M42 Junction 6 Development Consent Order Scheme Number TR010027

8.98 Applicant's Comments on any Additional Information or Submissions Received by Deadline 8

**Applicant's Comments on any Additional Information or Submissions
Received by Deadline 8**

Version	Date	Status of Version
1	15 November 2019	Final for submission at Deadline 9

Figure 7.3: DM AADT 24hr flows

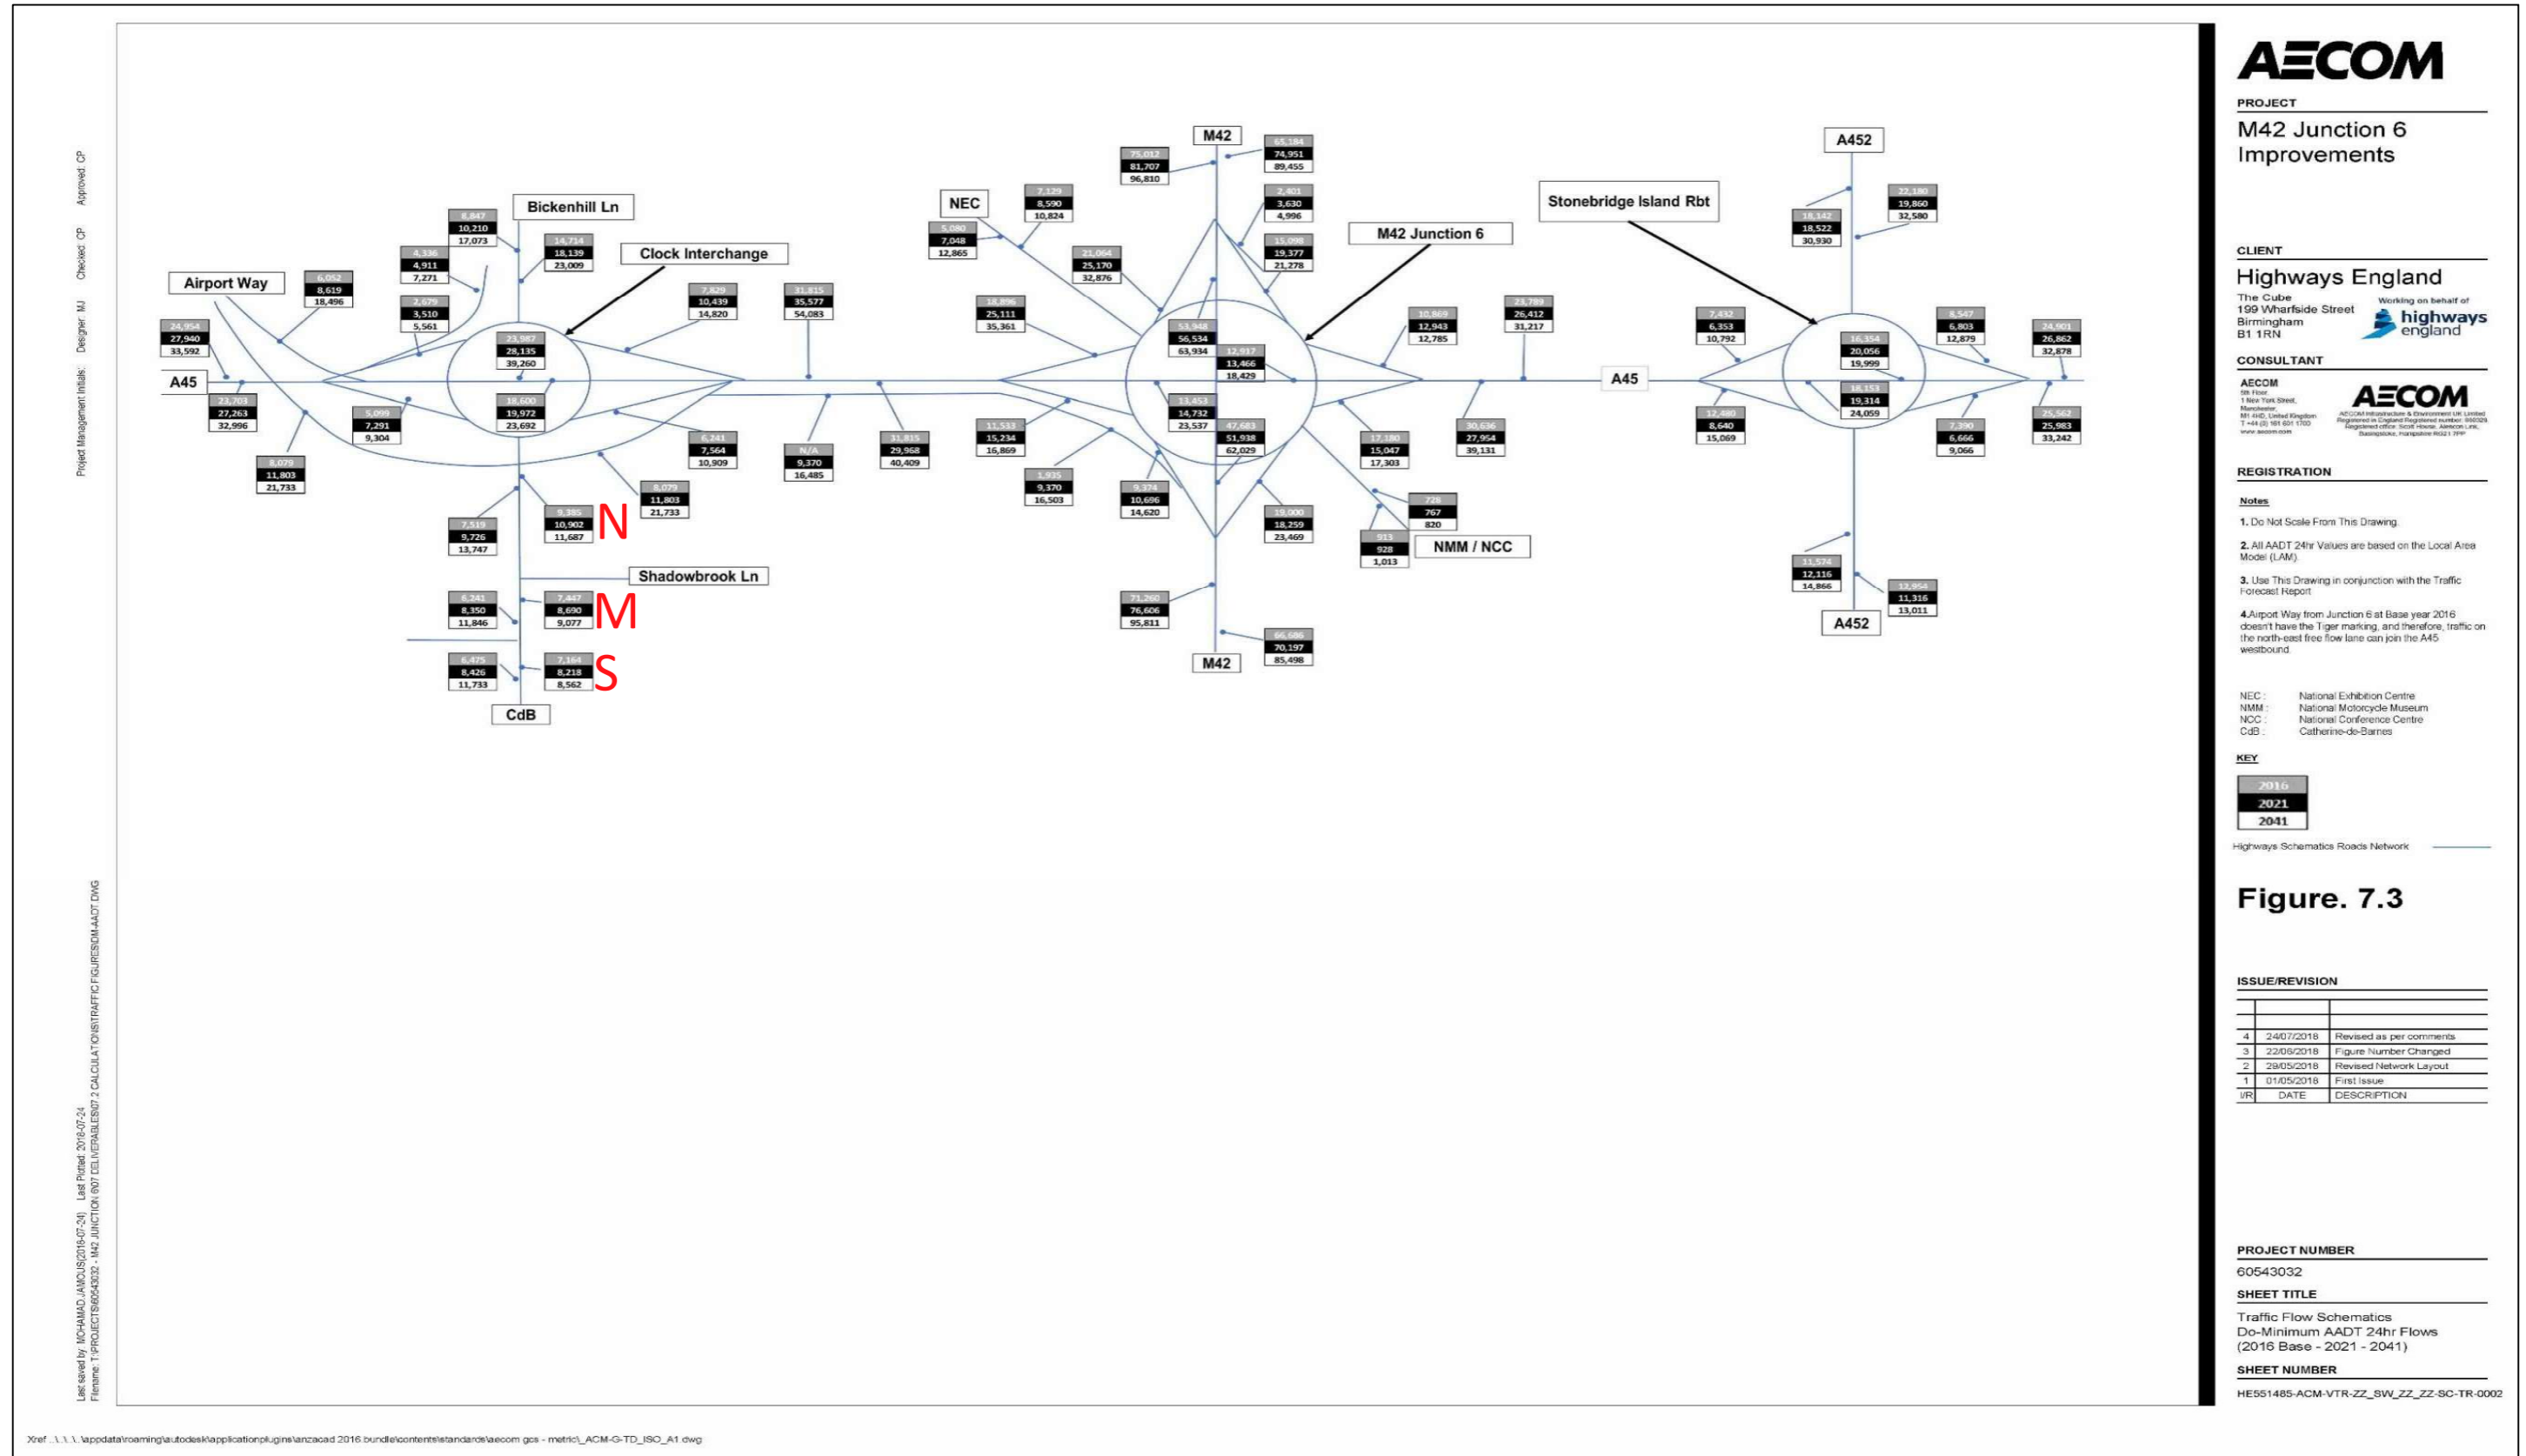
Submitted by	Title	Comments
		<p>- 12156 vehicles exit Bickenhill Roundabout but only 8348 vehicles will get to Hampton Lane Roundabout</p> <p>- In 2016, only 283 vehicles do not travel the full distance from Bickenhill Roundabout to Hampton Lane Roundabout but in 2041 this number has increased by almost 1250 per cent to 3808</p> <p>Comments on Southbound Traffic Flow (from Figure 7.4):</p> <p>The majority of vehicles that currently travel southbound from the Clock Interchange are using Catherine de Barnes Lane to travel to their destination via Hampton Lane Roundabout.</p> <p>The journey following completion of the Scheme will be as follows:</p> <ul style="list-style-type: none"> - Exit Clock Interchange onto the Mainline Link road - Leave the Mainline Link road and continue onto Bickenhill Roundabout via the Diverge Slip from proposed the Mainline Link road - Exit Bickenhill Roundabout and travel Southbound on the Realigned Catherine de Barnes Lane to Barber's Coppice Roundabout - Exit Barber's Coppice Roundabout and continue to Hampton Lane Roundabout <p>As the majority of these vehicles will exit Bickenhill Roundabout and travel Southbound on the Realigned Catherine de Barnes Lane to Barber's Coppice Roundabout, then continue from Barber's Coppice Roundabout to Hampton Lane Roundabout, the relevant Traffic Flows are section (B) and section (D).</p> <p>Highways England state that in 2041 the daily Traffic Flow from Bickenhill Roundabout to Barber's Coppice Roundabout (step 3 above) will be 12156 (section (B)). The Traffic Flow from Barber's Coppice Roundabout to Hampton Lane Roundabout (step 4 above) is stated as 8348 (section (D)), a difference of 3808. Highways England are forecasting that on a daily basis in 2041, 3808 vehicles that travel south from Bickenhill Roundabout to Barber's Coppice Roundabout are doing so to get onto the Mainline Link road, as they are not continuing to Hampton Lane Roundabout. That amounts to almost a third of all southbound vehicles.</p>

Submitted by	Title	Comments
		<p>It is unlikely that 3808 vehicles have left the Mainline Link road will make the same mistake on a daily basis and are simply travelling back to the Clock Interchange or are leaving Bickenhill on a daily basis so where have these 3808 vehicles come from?</p> <p>If step 2 of the journey is included, the Traffic Flow for the Diverge Slip from proposed Mainline link to Bickenhill Roundabout (section (F)) is 13362. The Traffic Flow from Barber's Coppice Roundabout to Hampton Lane Roundabout (step 4 above) is stated as 8348 (section (D)), the difference is 5014 vehicles. Are Highways England suggesting that on a daily basis in 2041, 5014 vehicles will exit the Mainline Link road but will not continue to Hampton Lane Roundabout?</p> <p>Comments on Northbound Traffic Flow (from Figure 7.4):</p> <p>The majority of vehicles that currently travel northbound from Hampton Lane Roundabout are using Catherine de Barnes Lane to travel to their destination via the Clock Interchange.</p> <p>The journey following completion of the Scheme will be as follows:</p> <ul style="list-style-type: none"> - Exit Hampton Lane Roundabout onto the Realigned Catherine de Barnes Lane and continue to Barber's Coppice Roundabout - Exit Barber's Coppice Roundabout onto the Merge Slip to the proposed Mainline Link road - Continue on the Mainline Link road to the Clock Interchange <p>However, a small number of vehicles will be accessing Bickenhill.</p> <p>The journey from Barber's Coppice Roundabout to Bickenhill Roundabout (and onto Bickenhill) will be as follows:</p> <ul style="list-style-type: none"> - Exit Barber's Coppice Roundabout onto the Realigned Catherine de Barnes Lane and continue to Bickenhill Roundabout - Exit Bickenhill Roundabout onto the Realigned Catherine de Barnes Lane and continue to Bickenhill <p>The majority of vehicles that exit Hampton Lane Roundabout onto the Realigned Catherine de Barnes Lane will be accessing the Mainline Link road via the Merge Slip off Barber's Coppice Roundabout, and the relevant Traffic Flows are section (A) and section (E). However, some vehicles will exit Barber's Coppice Roundabout onto the Realigned Catherine de Barnes Lane and</p>

Submitted by	Title	Comments
		<p>- In 2041, 12953 more vehicles will exit Clock Interchange traveling south and 11275 of these vehicles will continue onto the Mainline Link road. It appears there will be an increase of 1678 vehicles using the Realigned Catherine de Barnes Lane in 2041</p> <p>Given the above it is difficult to conclude that Highways England are correct when stating the annual average daily Traffic Flow southbound to Catherine-de-Barnes Lane shall be 8,532 under the do minimum scenario compared to 8,348 under the do something scenario.</p> <p>In fact, it is glaringly obvious that they have simply cherry-picked data in an attempt to justify their argument.</p> <p>It also appears that their Traffic Flow data is seriously flawed.</p> <p>As HE have used this flawed Traffic Flow data in their air quality assessment document 'TR010027-000139-TR010027_M42J6_6-1_Environmental_Statement_Chapter_6' and noise assessment document 'TR010027-000145-TR010027_M42J6_6-1_Environmental_Statement_Chapter_12' one must assume that these documents are not a true reflection of the impact of the scheme and they must be updated accordingly before any decision is made by the ExA.</p> <p>The Applicant comment:</p> <p>The Applicant's response to Action point 20 within Volume 8.86 [REP7-011/Volume 8.86] referred to southbound traffic along Catherine-de-Barnes Lane where it reaches Catherine-de-Barnes roundabout, not where it will reach the new Barber's Coppice roundabout. This is because the Applicant is of the view that this is the area currently most susceptible to the congestion described by Mr O'Reilly.</p> <p>Mr O'Reilly's subsequent comments largely relate to the traffic flow numbers not 'adding up' between road sections within the Transport Assessment Report (TAR) [APP-174/Volume 7.2]. The comments also question the validity of the traffic flow data which has been used to inform the air quality and noise assessments.</p> <p>The Applicant can confirm that the traffic flows presented in Figures 7.1 to 7.6 of the TAR provide a summary of the forecast flows produced by the M42 Junction 6 Local Area Model (LAM). As the figures referred to by Mr O'Reilly are summary figures, these do not provide flow information for</p>

Submitted by	Title		Comments
			<p>every road section which is why the totals do not add up and are not meant to. The Applicant's selection of links was made to simplify the presentation of the flows while allowing some comparisons to be made between forecast years and scenarios. The full information is contained in the LAM and informed both the traffic and environmental assessment, including the assessments of air quality and noise.</p>
Philip O'Reilly	Response to action points: ISH 7 on the draft Development Consent Order – 23 rd October 2019	16	<p>Philip O'Reilly comment:</p> <p>I can confirm a letter from Chris Harris (Highways England) was attached to an email received from Lydia Barnstable (AECOM) on 25th October 2019 and marked 'Private and Confidential'. However, it does not address the concerns I have raised. In short:</p> <ul style="list-style-type: none"> - The letter advises that I should engage a professional advisor but does not confirm that Highways England will meet the cost. - The letter confirms that works will be undertaken but does not provide any information or plan showing the extent of those works. - It is disappointing to say the least that Highways England are still unable to confirm how my property is affected by their scheme. - The letter does not confirm how the main access and the rear access to my property will be treated. - Instead of agreeing any fencing or boundary treatment to my property directly with Highways England it will need to be agreed with the Principal Contractor. - Although the works in front of my property have not changed a great deal since January 2018 Highways England have still not completed the Land Registry checks (but advise that they will be completed by 2nd November 2019) and therefore cannot confirm what land will revert to my ownership under the ad medium filum rule. No information has been provided prior to Deadline 8. - I would prefer to have control, and therefore ownership, of as much of the land outside the current boundary to my property up to the realigned Catherine de Barnes Lane to ensure it is properly maintained.
